From: Juan Baeza
Sent: 30 July 2018 16:46
To: Planning.Responses
Subject: FW: CM/19/18/L

From: Martyn White **On Behalf Of** Conservation Officer
Sent: 30 July 2018 16:44
To: Juan Baeza
Subject: CM/19/18/L

CM/19/18/L

SKYPOD - PITCHED PVC-U SKYLIGHTS

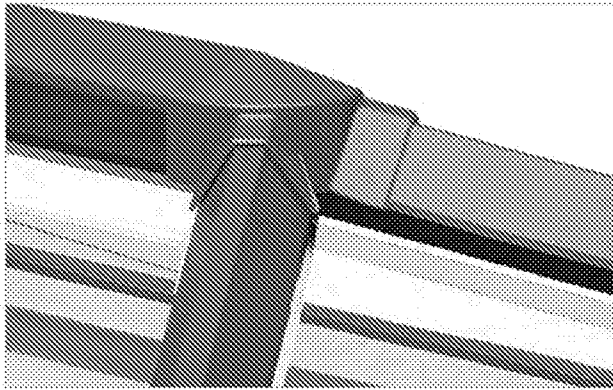
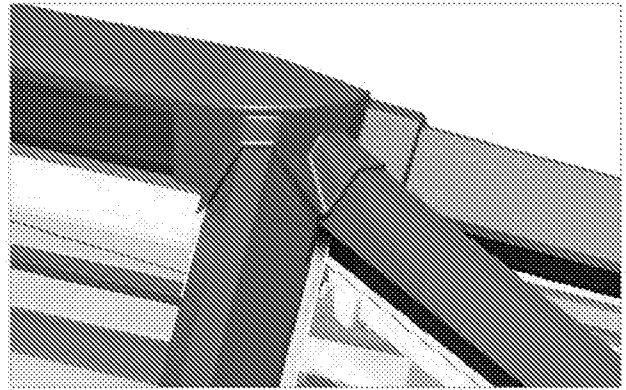
It is assumed that the replacement skylight will be of a similar colour as existing? This may need to be confirmed.

Drawing Name  
Plan and Elevations  
Existing and Proposed

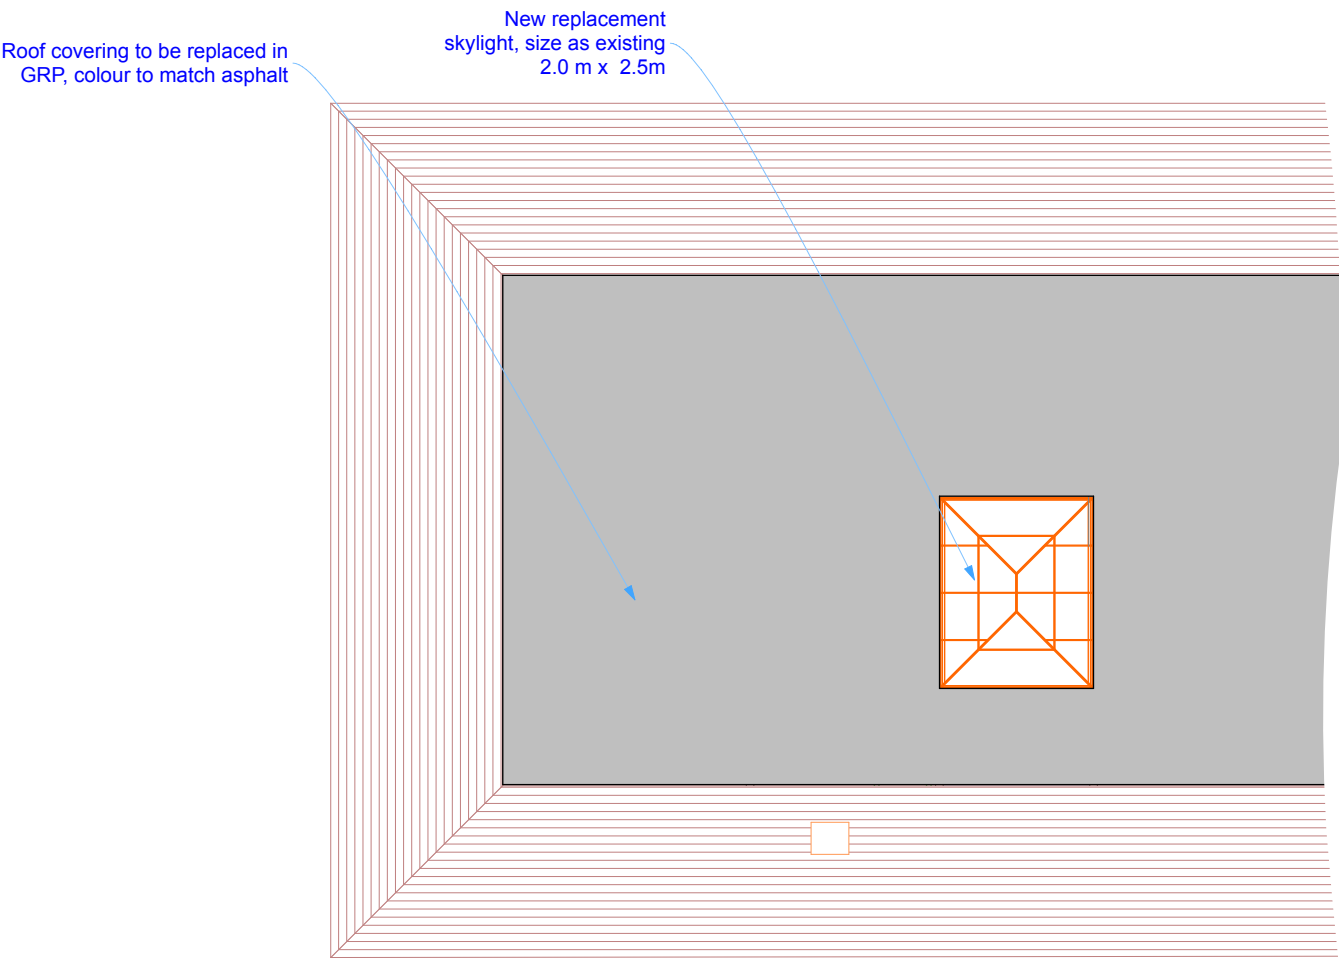
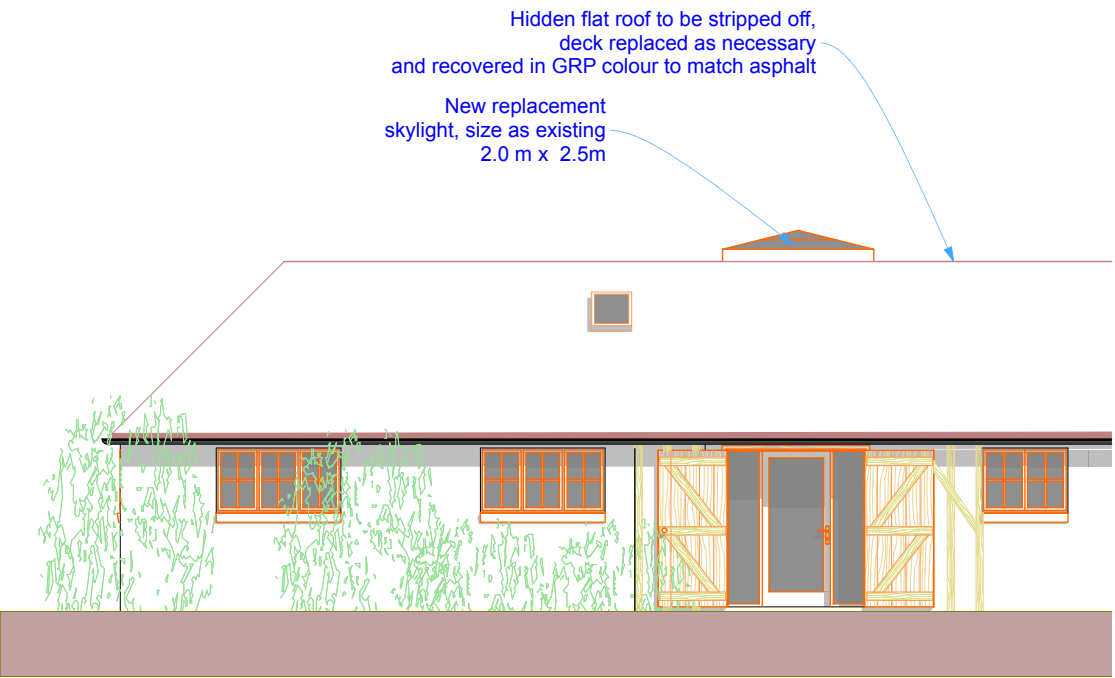
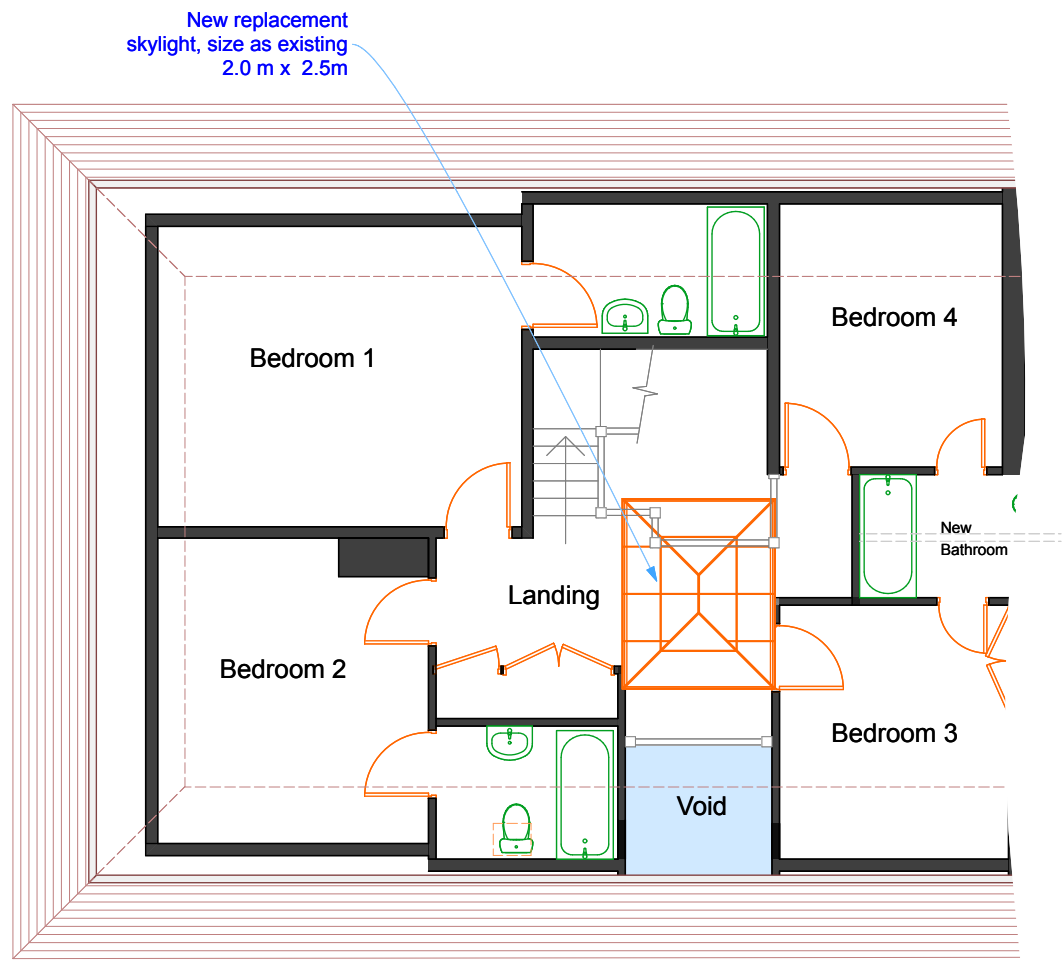
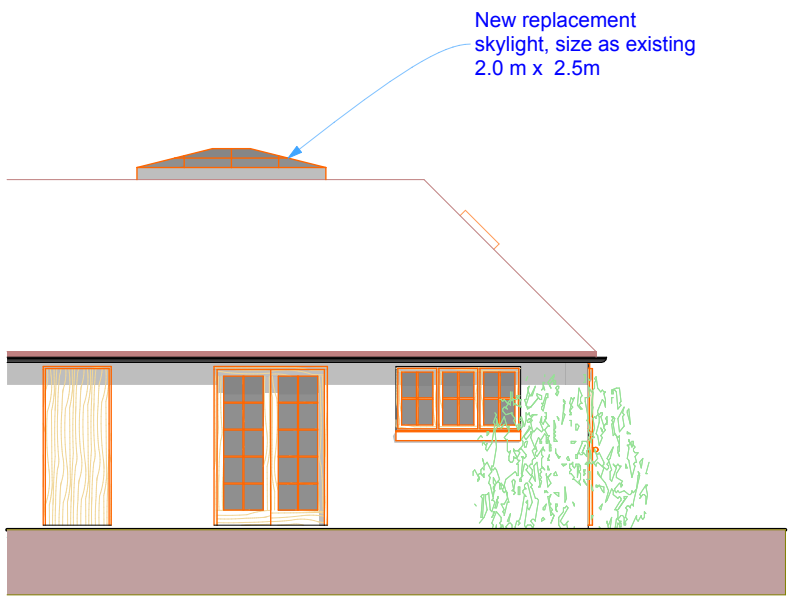
The application only appears to relate to the existing flat roof and skylight. These comments only relate to these two areas of the building.

The removal and replacement of the existing felt material/deck and skylight do not appear to affect any structure of heritage importance. As a consequence, such a proposal is supported. The replacement materials will, on balance, reflect the character of the building, and have been used elsewhere.
